NSW RURAL FIRE SERVICE

Your reference: SSD 7419
Our reference: D16/2436

Modification to proposed new habitat and eco-tourist facility at Taronga Zoo Bradleys Head Road Mosman

02 SOUTH ELEVATION
1:100

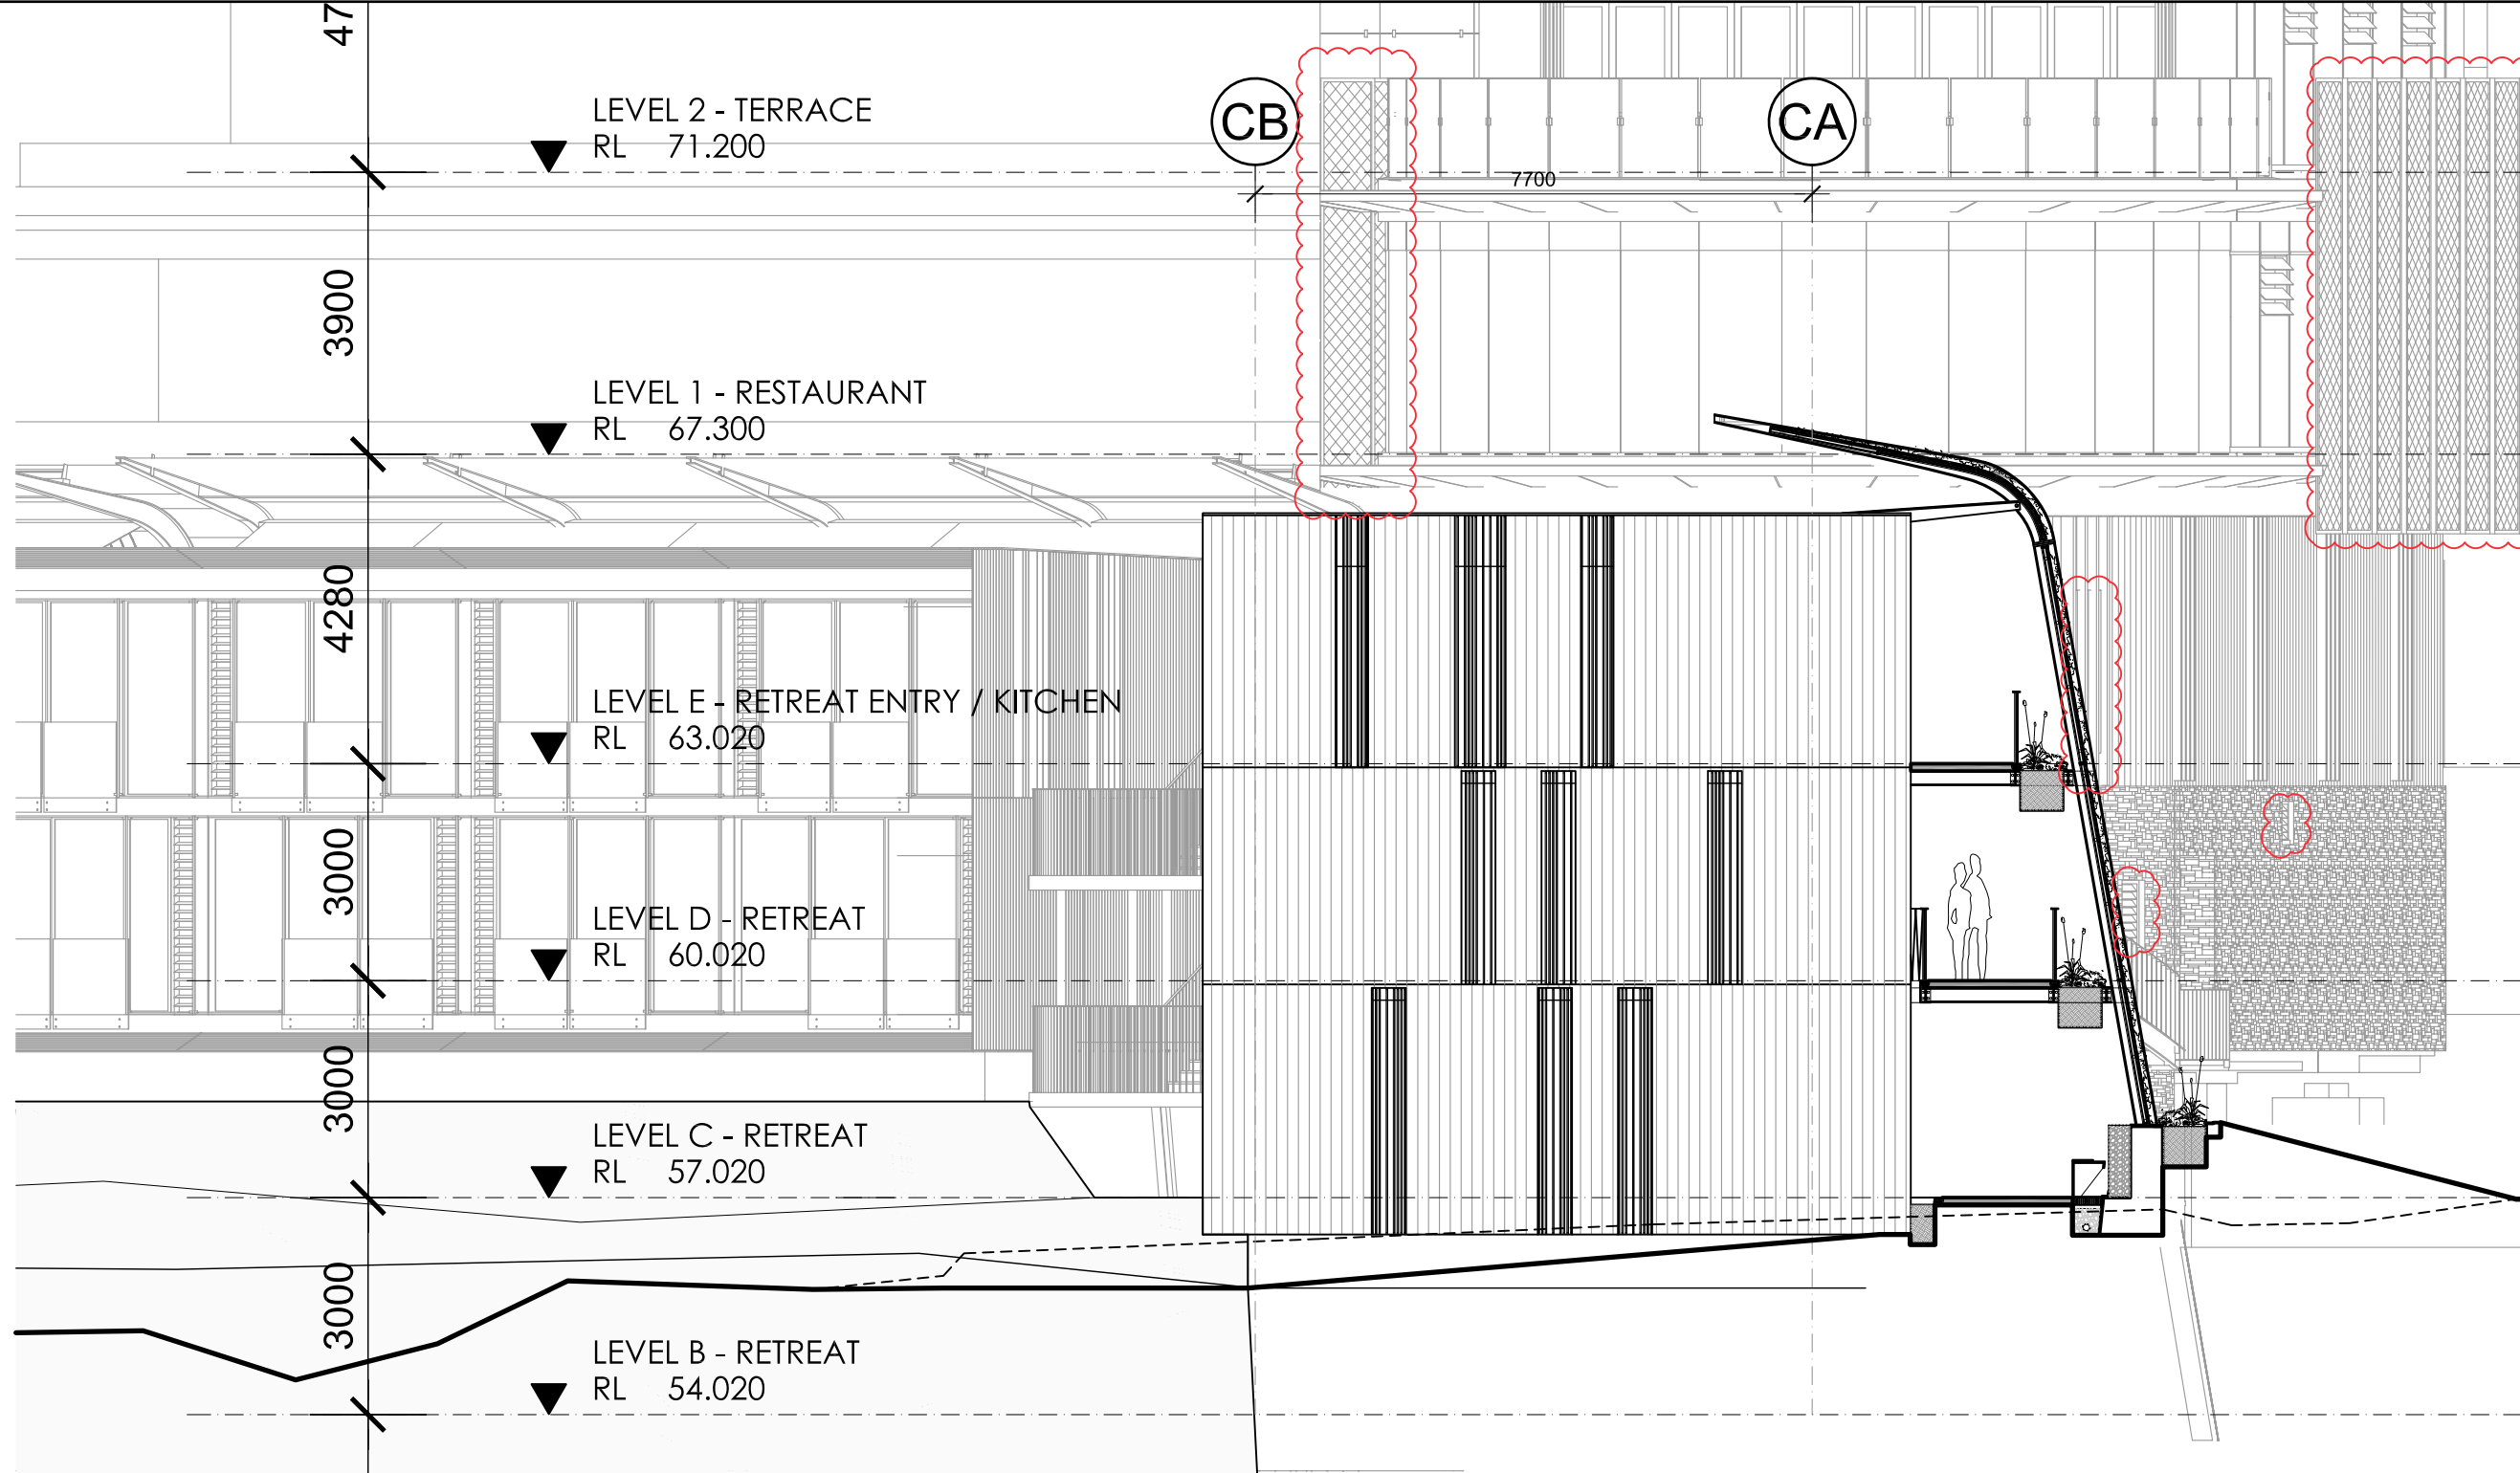
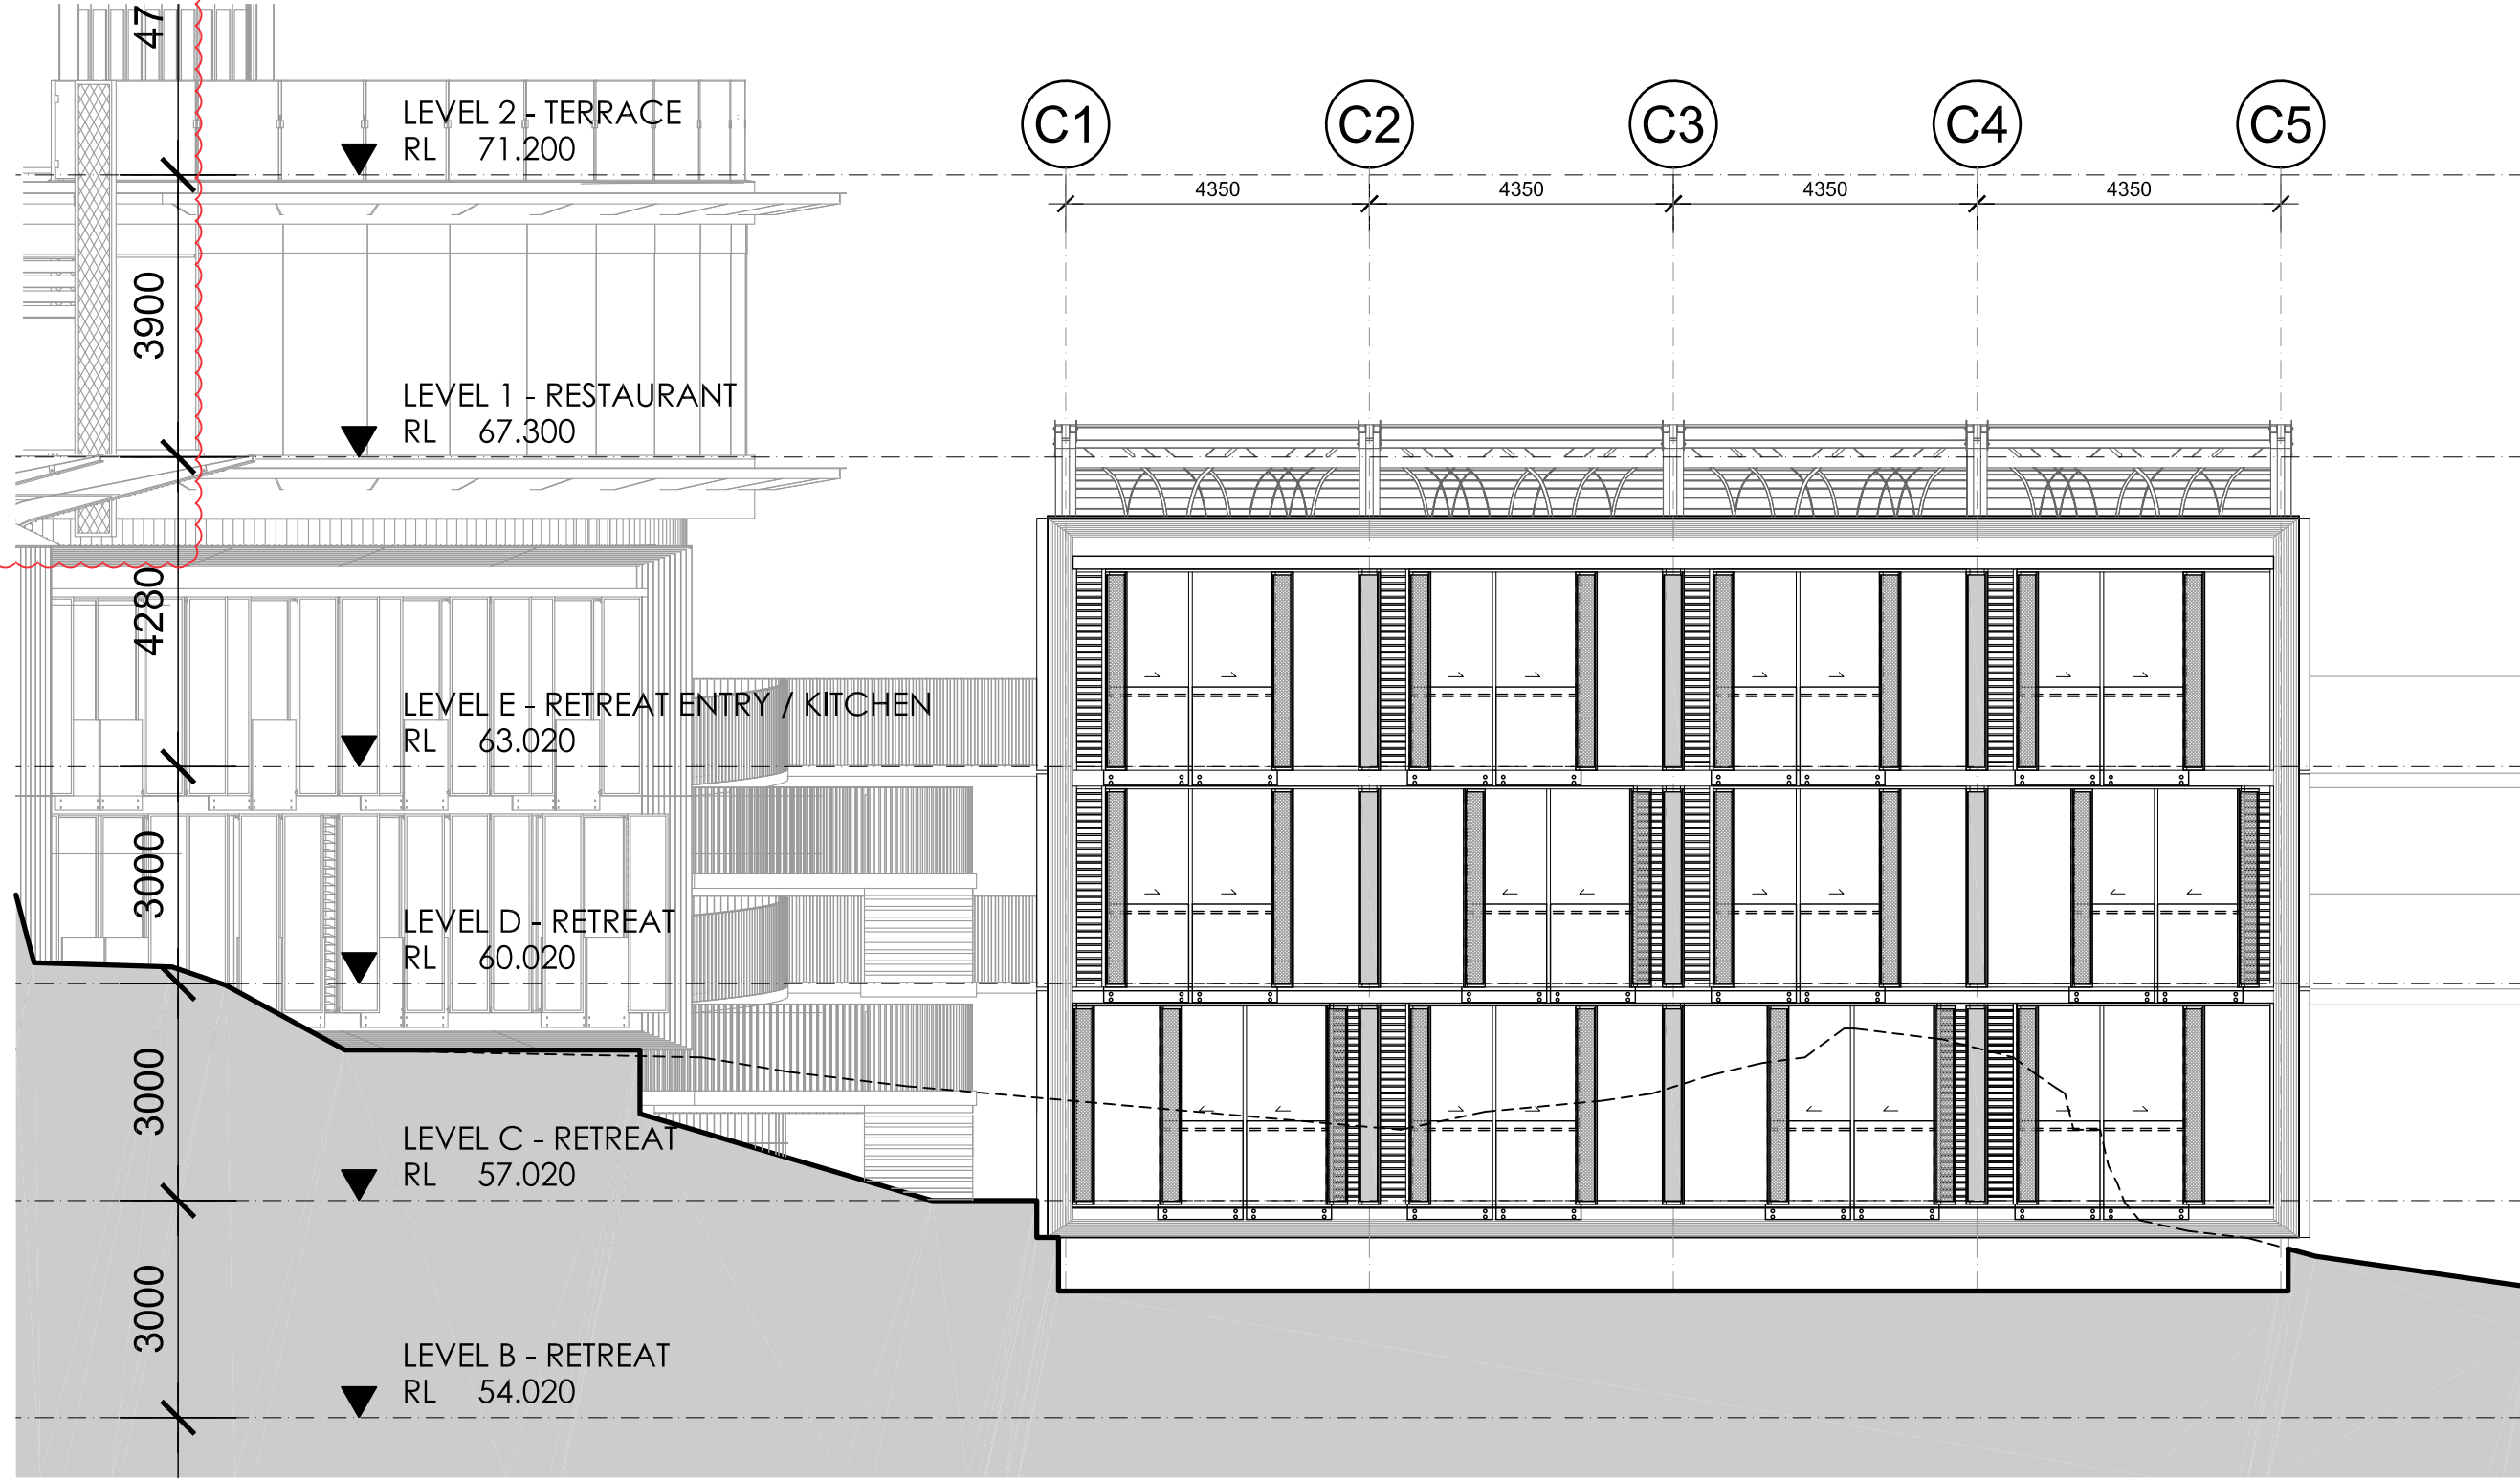
automated sprinkler system can be considered for the southern façade of Pod D given the management of vegetation on site. The external northern and eastern facades of Pod B do not require these sprinklers based on the BALs.
